Appeal Decision

Appeal Ref: APP/A2525/D/25/3372366

Markenville, 17 Broadgate Road, Sutton St James, Spalding, PE12 0EL

- The appeal is made under section 78 of the Town and Country Planning Act 1990 (as amended) against a refusal to grant planning permission.
 - The appeal is made by Mr A Coupe and Miss Z Roberts against the decision of South Holland District Council.
 - The application Ref is H20-0417-25.
 - The development proposed is the demolition of conservatory and erection of single-storey front and side extensions.
-

Proposed Front (NW) Elevation
Scale 1:100

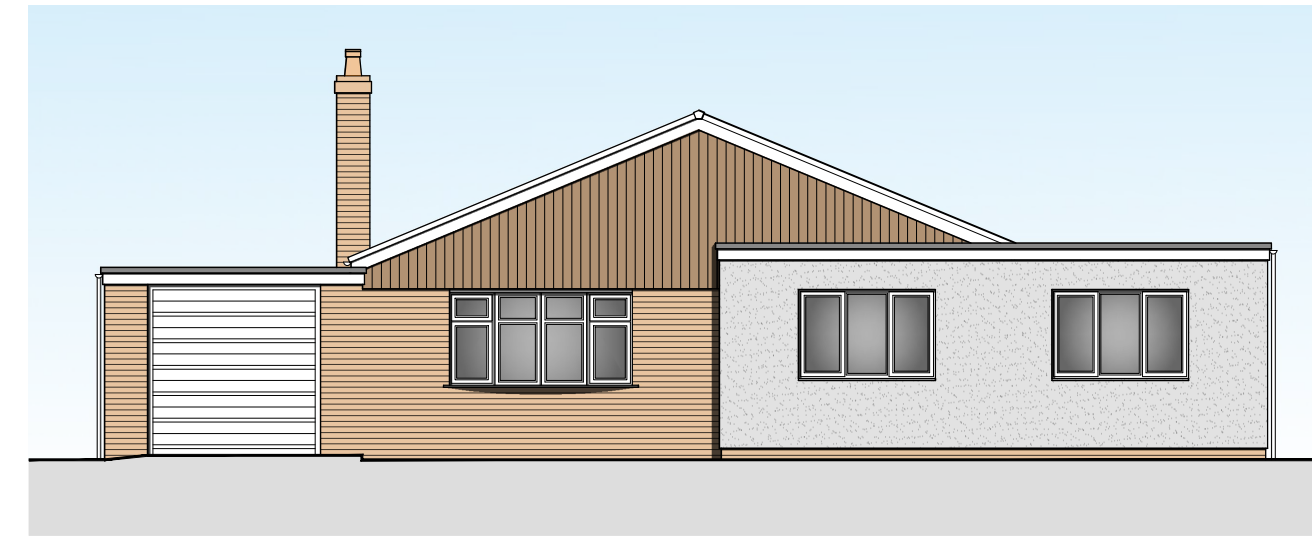
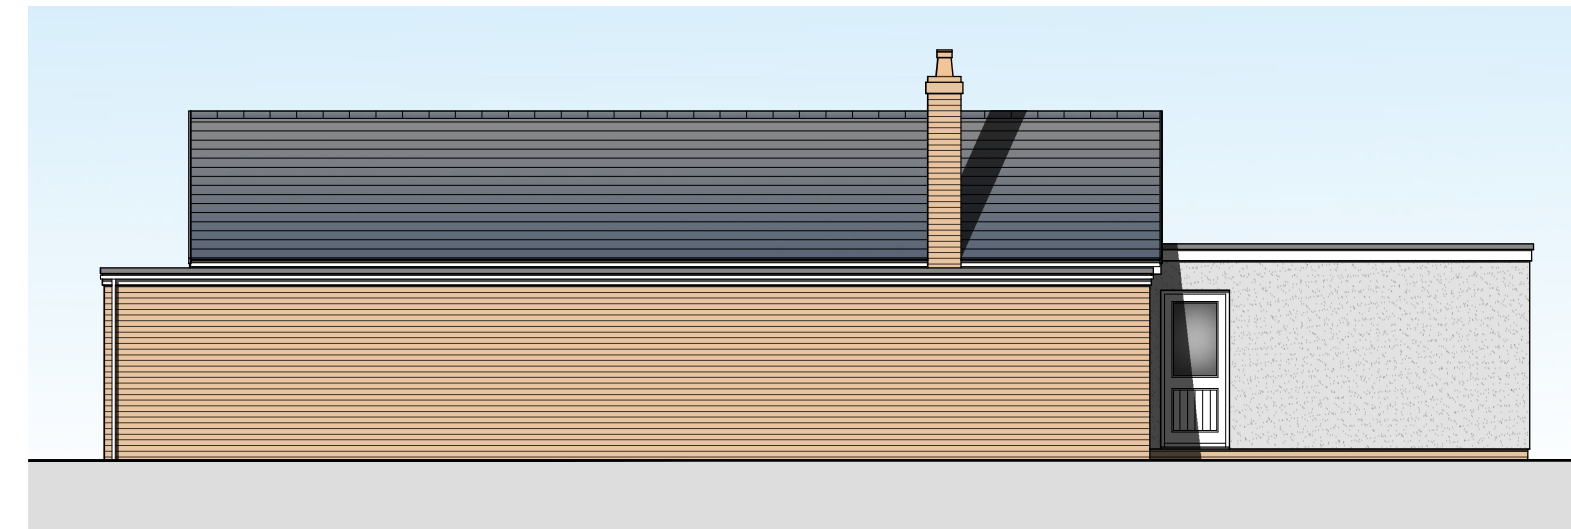
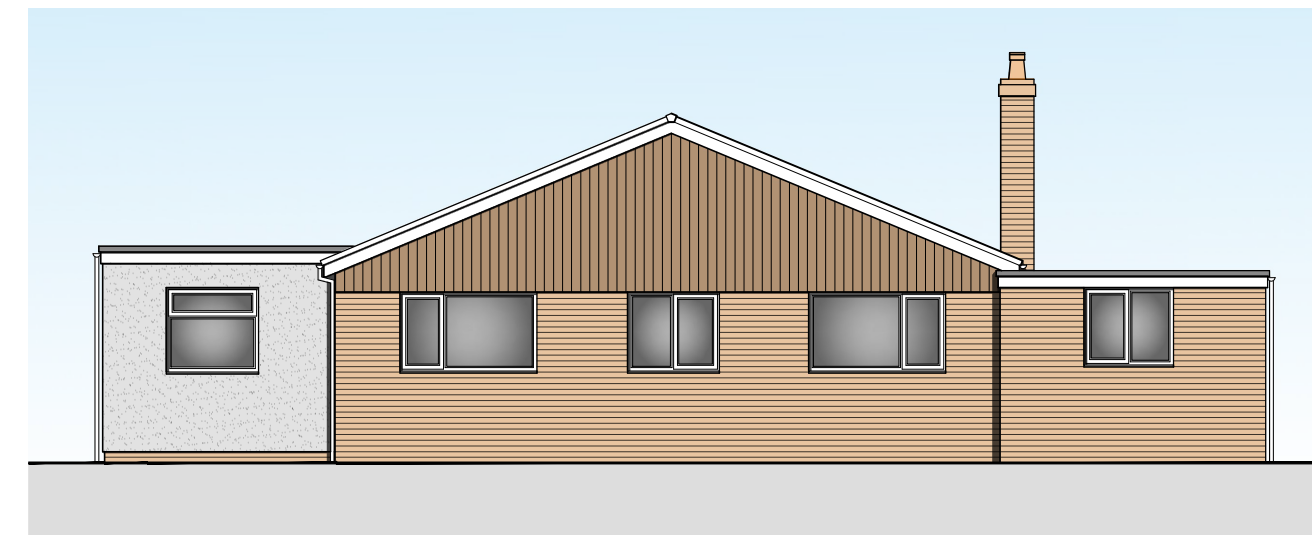
5. The proposal is to demolish an existing and relatively small conservatory at the front of the property and construct flat-roofed single-storey front and side extensions. The extensions would provide two additional bedrooms, a bathroom and an enlarged garage. I have no doubt that the extensions would enhance living conditions within the property for the appellants.

6. The Council considers that the design of the proposal is 'poor' and that the development would have a negative impact on the character and appearance of the area. As such, the Council states that it would conflict with Policies 1, 2, and 3 of

7. The appellants state that the proposed side extensions could be constructed as Permitted Development. Whilst that may be the case, my main concern is the design and appearance of the front extension. Although it would be positioned some 7m from the highway, it would be highly visible from Broadgate Road, and its box-like appearance would appear incongruous and detrimental to the appearance of both the appeal dwelling and the streetscene. In my opinion, a front extension of a different design could be acceptable, but this would require further discussion with the Council. As submitted however, the proposal would conflict with the provisions of both the LP and the NPPF, as referred to above.
